RE: SSI-8863 - Submission in relation to the Western Harbour Tunnel & Warringah Freeway Upgrade and its impacts upon Little Zak's Academy at 6-8 Waterloo Street, Rozelle.

This submission relating to SSI-8863 ('the project') is made on behalf of Little Zak's Academy which is a childcare centre scheduled to open in June/July 2020 at 6-8 Waterloo Street, Rozelle ('Little Zak's site').

**Figure 22-8 Victoria Road construction support site landscape character zones and viewpoints**

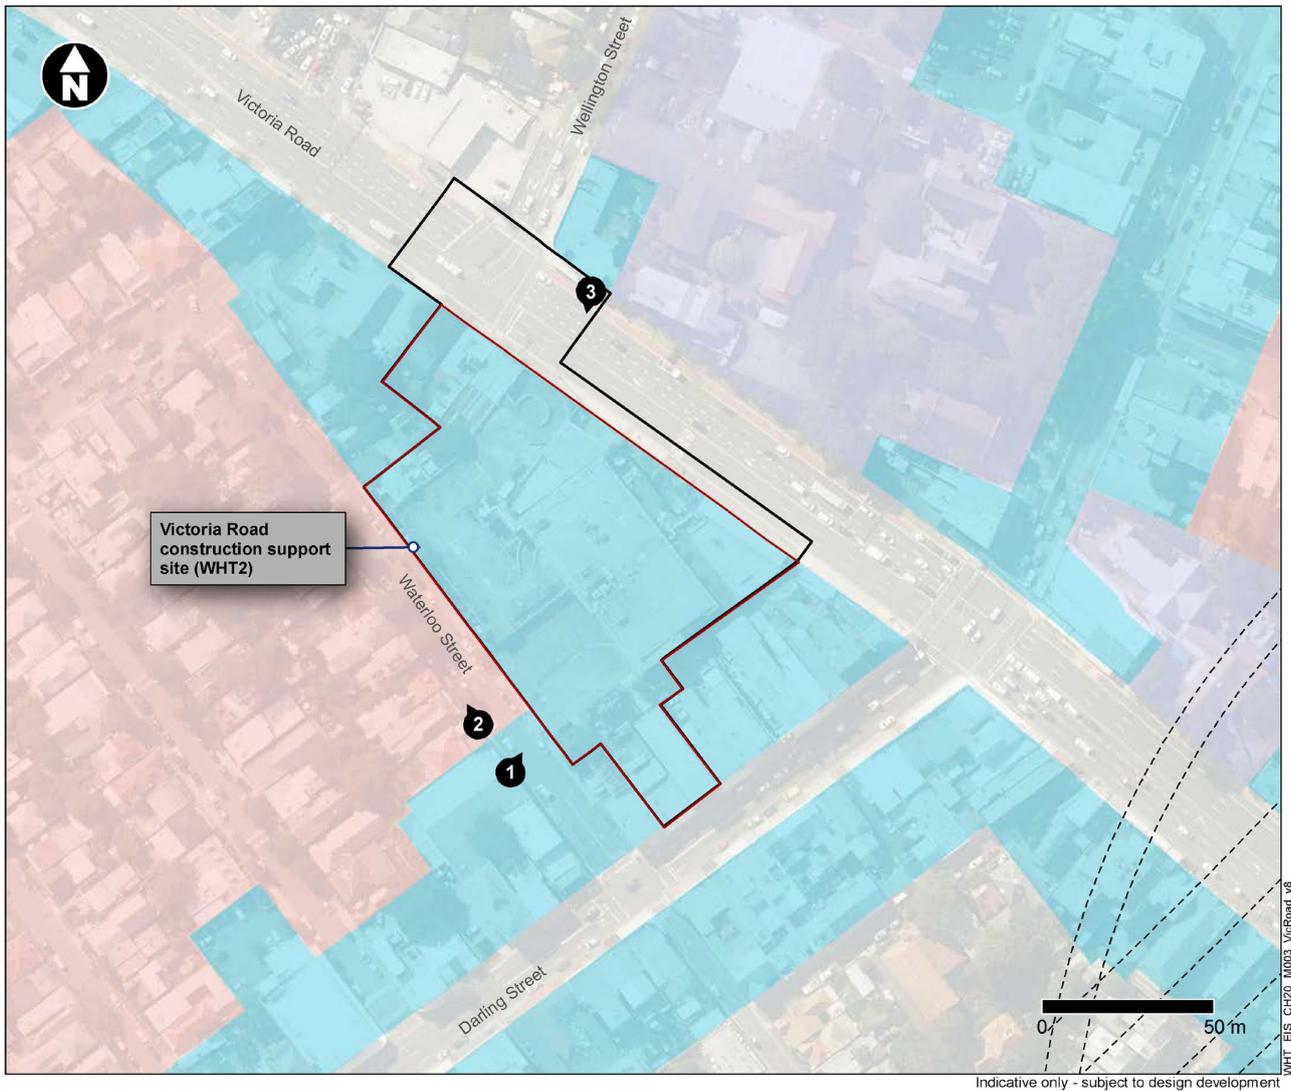
The indicative layout of the WHT2 and the location of Little Zak’s academy is shown in figure 2. It seems very likely that the immediate northern neighbouring residential building is among those 27 receivers which will be ‘highly noise affected’ meaning an impact of >75 dB(A). Little Zak’s site, as a child care centre with a lower daytime affectation threshold is almost certainly highly impacted and may be among the 11 receiver buildings that will be noise affected during tunnel construction.

The predicted construction noise levels shown in EIS Appendix G, Table 5-27, show that the noise levels during construction could reach as high as 83 dB(A) which exceeds the 50 dB(A) threshold applied to childcare centres by 33 dB(A). This impact would be extreme and warrants specific consideration in the assessment.

As shown in figure 2, the Zittle Zack's site is within 50m of an area identified for storage. I note that as per EIS Chapter 23 'Hazards and Risks', WHT2 will be used for the storage of dangerous goods and hazardous substances. Section 23.2.1 states:

The indicative site plan has identified unspecified storage areas less than 50m from Little Zak's Academy. Chapter 23 of the EIS identifies that the Victoria Road construction support site will store dangerous goods and hazardous materials. We ask that the location of the childcare centre be considered in the screening phase relating to the storage of any dangerous goods or hazardous materials.
